Application number: 2023/60/93539/E	
What is the application for?:	Outline application, including the considerations of access appearance, layout,
Address of the site or building:	Land adj, Ledgard Bridge Mill, Back Station Road, Mirfield, WF14 8NZ
Postcode:

Type of comment: An objection	
Do you wish your comments to be published on the website anonymously?	Yes
<p>The proposed flood evacuation walkway is completely and utterly unsuitable, dangerous and represents significant risks to safety and security. Residents will still need to get through flood water to reach the walkway as the flood water breaches the river and then flows across the carpark at considerable force and speed towards the existing narrow exit onto Back Station Road.</p> <p>The plans state that residents will be required to 'step on parapet and swing legs over the wall to effect escape'. This demonstrates the total and complete contempt the applicant has for the residents of the existing building. Residents who are elderly cannot possibly get off the walkway and onto Calder Road safely. No consideration has been given to residents who have young children and pushchairs. The walkway is also in breach of the Equali

Flood Warning Procedure – Safe Exit Route overlaid on JBA 100yr+CC23% flood map

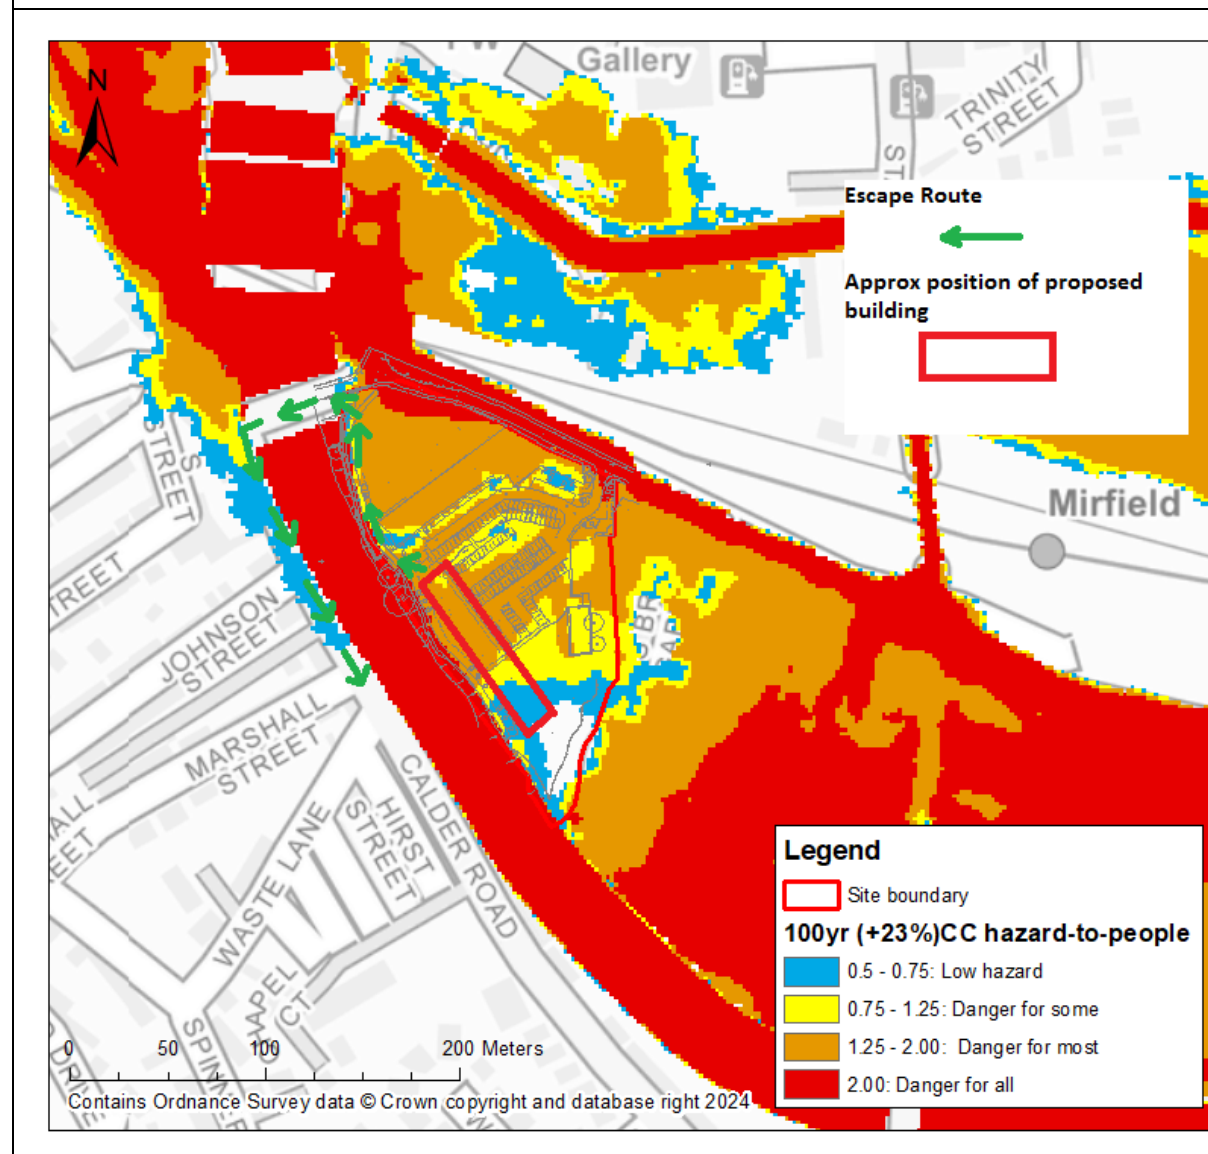
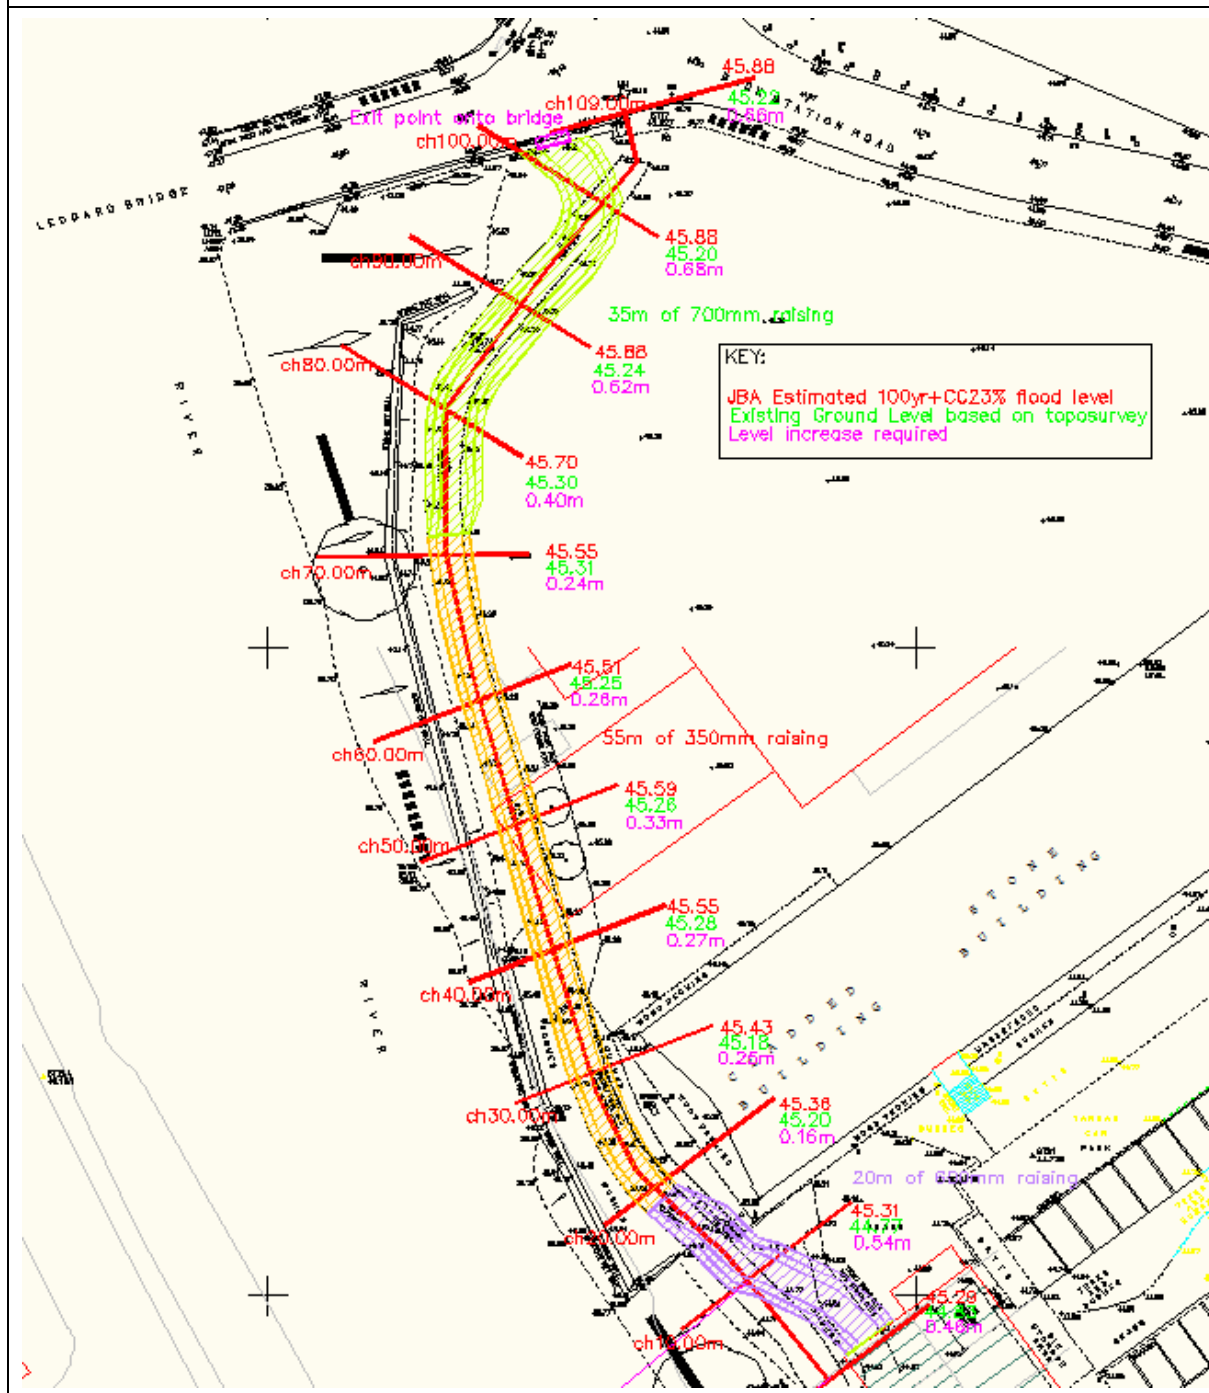
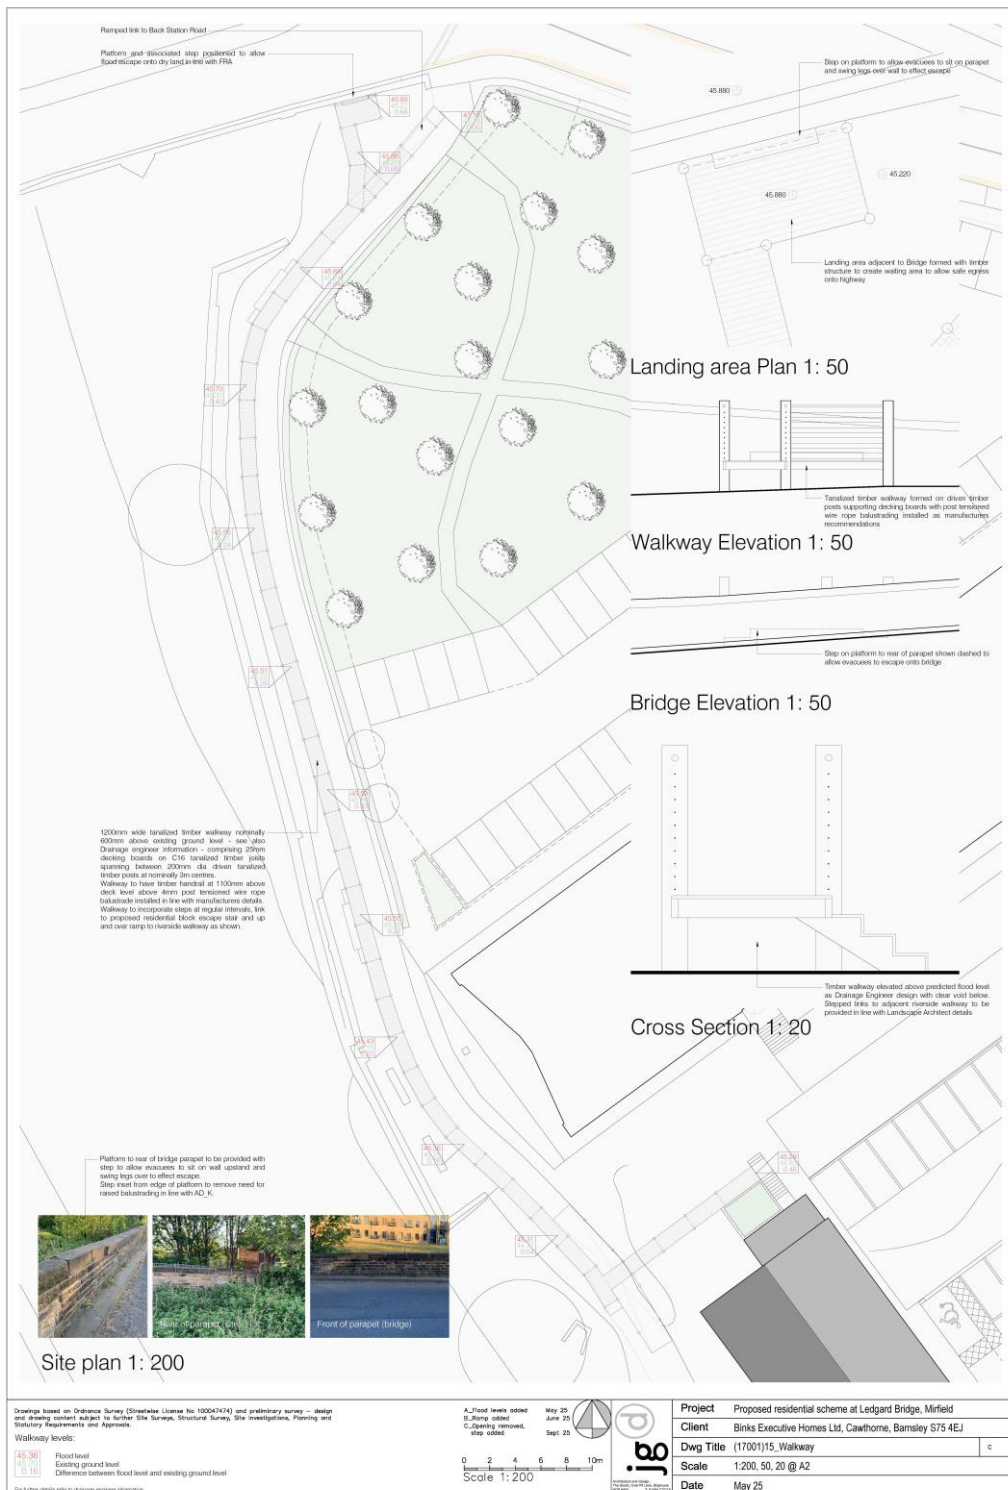
There is no safe escape route from Calder Road as the river breaches all surrounding roads i.e. Newgate, Back Station Road and Chadwick Fold, residents will therefore be trapped on Calder Road.

The river levels when at full flood have reached 5.40m above normal levels and are running extremely fast with debris such as trees and other large objects being projected downstream at significant speed and force. The actual effect of flooding on this site has been vastly and deliberately understated by the applicant. The water level under Ledgard Bridge during flooding exceeds the lowest level of the bridge, this causes significant backlog and blockages of debris until the current reaches such force that this is forcibly ejected downstream. The proposed evacuation bridge is only a few metres downstream from Ledgard Bridge, is significantly lower and being made of wood cannot possibly withstand the force of the water and more importantly the debris hitting it at speed.
